CITY OF ALBUQUERQUE

February 12, 2016

**Re: Independence Square, 6701 Jefferson St NE
Erosion Sediment Control Plan
Engineer's Stamp Date 1-29-16 (E17E076)**

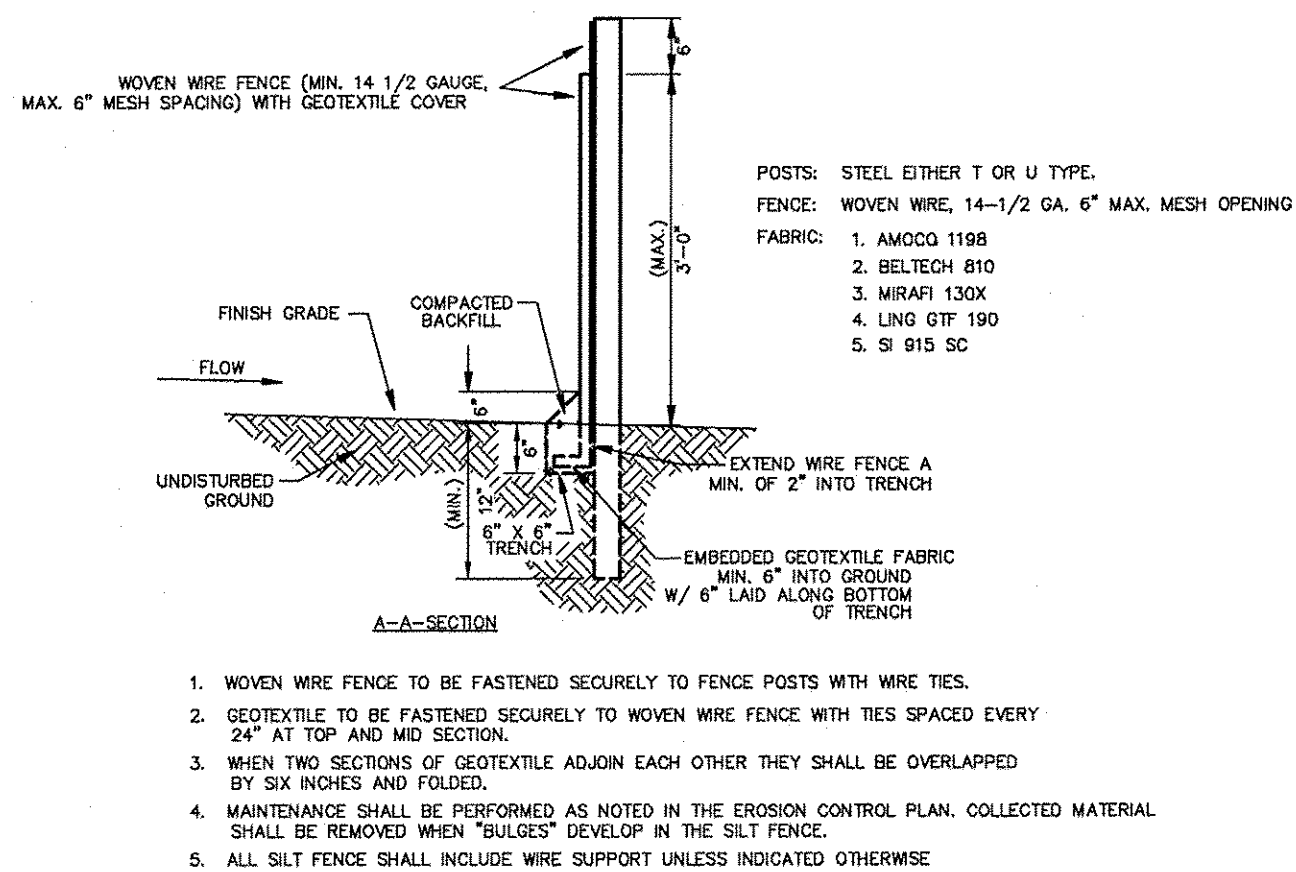
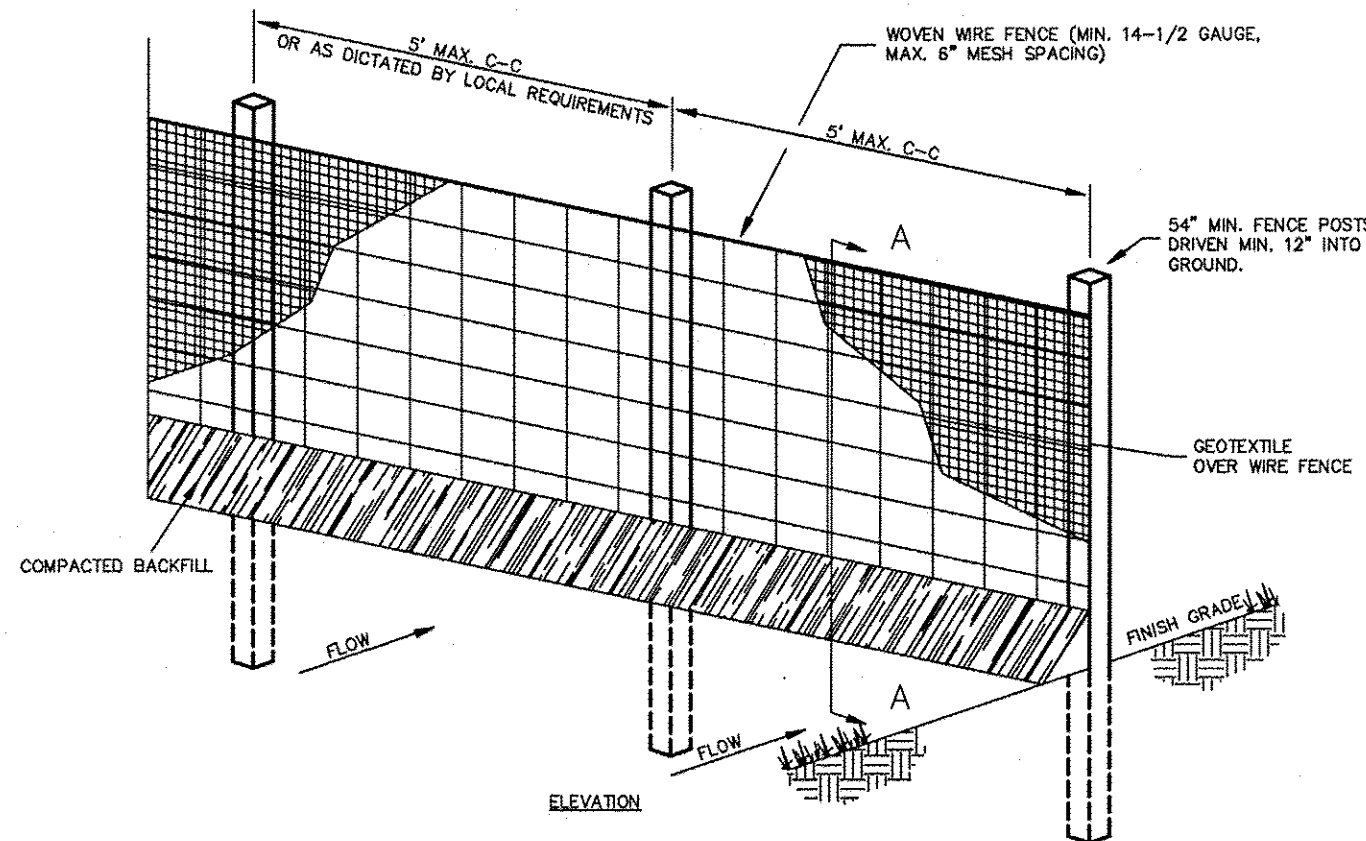
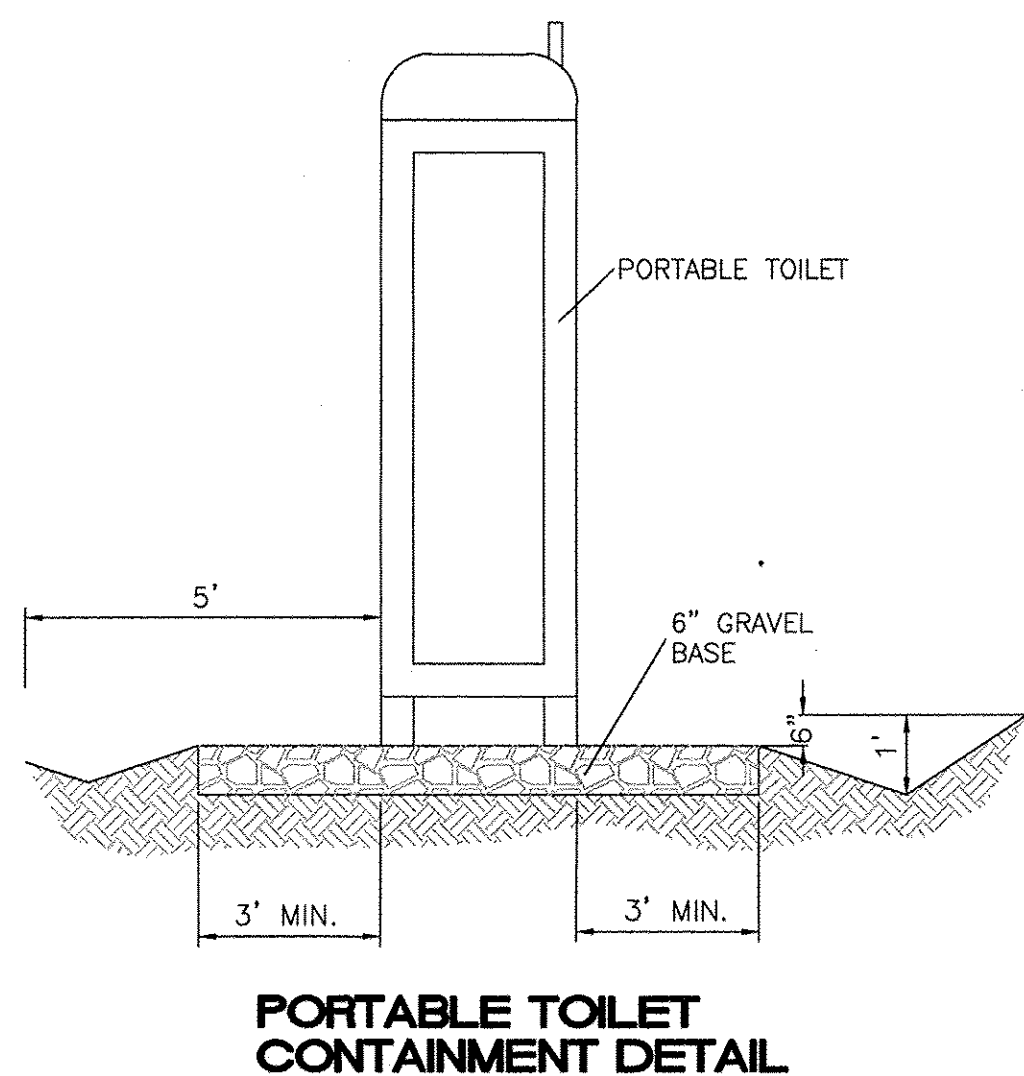
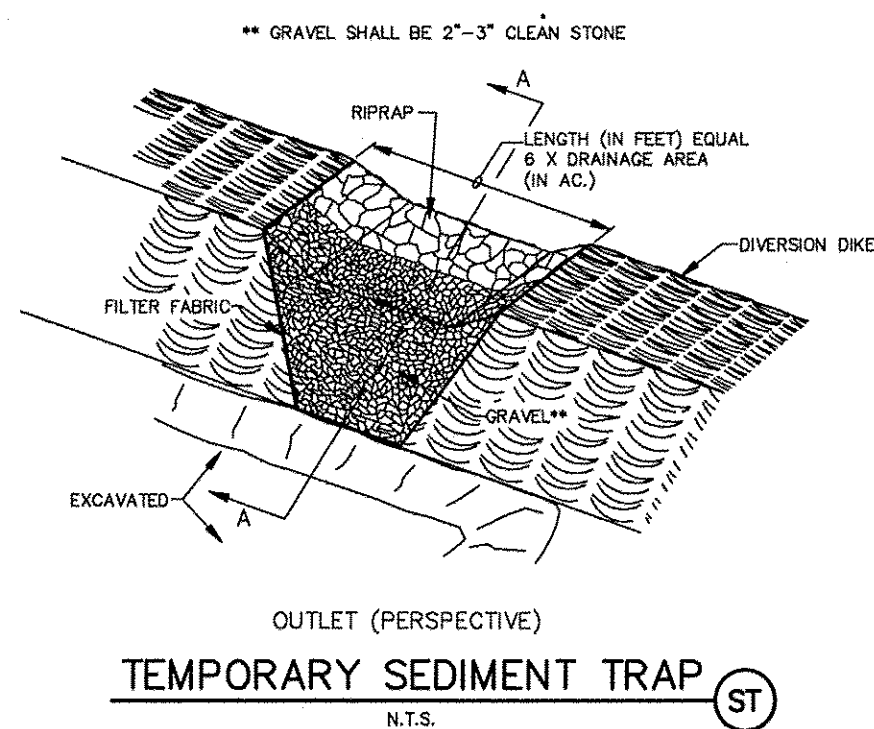
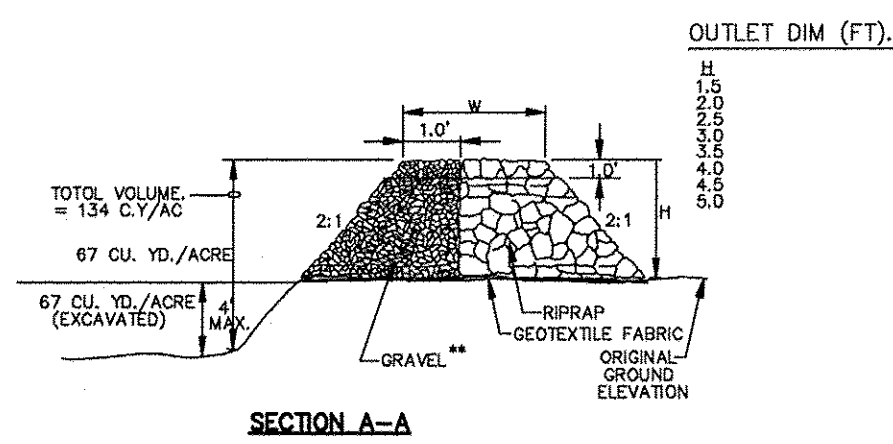
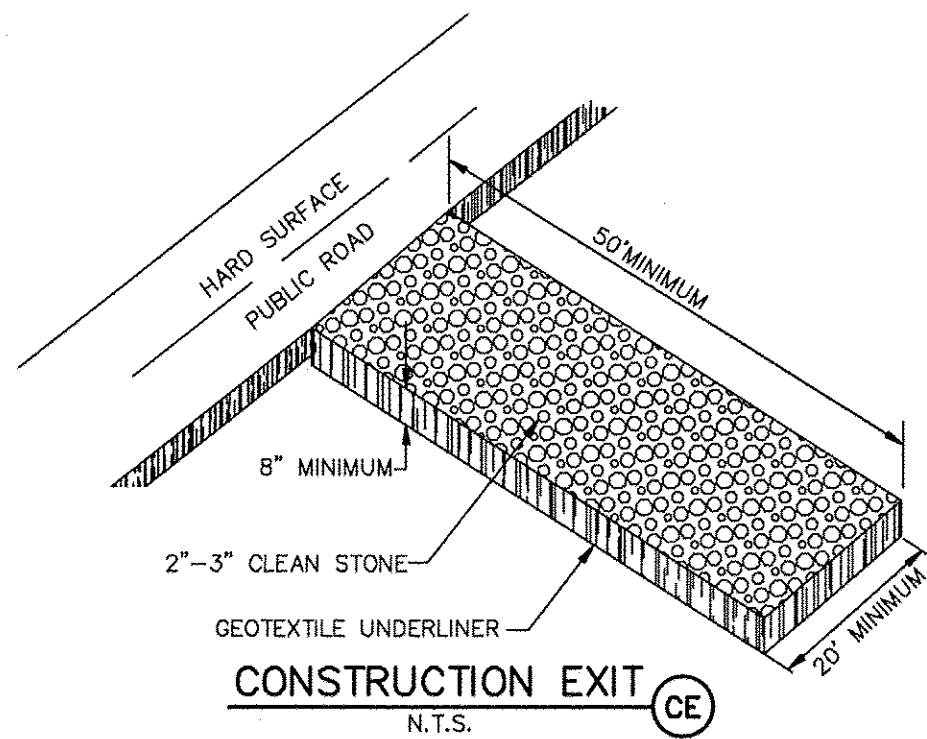
1. Provide inlet protection for the pond outfall that drains to the Pino arroyo or an acceptable pond outfall detail that shows the lowest orifice or grate elevation high enough so the pond can effectively work as a sediment basin.

2. There appears to be an inlet downstream of IP4 that should have inlet protection.
3. Include a keyed note for the utility cut for the storm drain to the north that the dirt from the utility cut should be piled on the uphill side of the cut and that the area is to be swept when the work is complete. If the work is done in segments, the area should be swept when the segment is complete.

4. Revise the "maintenance" note that an inspection is required within 24 hours of the end of a 0.25 inch rainfall rather than 0.5 inch. (paragraph 4.1.2 CGP)

5. Include a note that SWPPP measures for the connection to the South Pino Arroyo will be per AMAFCA.
6. Per our discussion 2-11-16, a separate plan is to be submitted for the Work Order construction and utility cuts in Jefferson St.
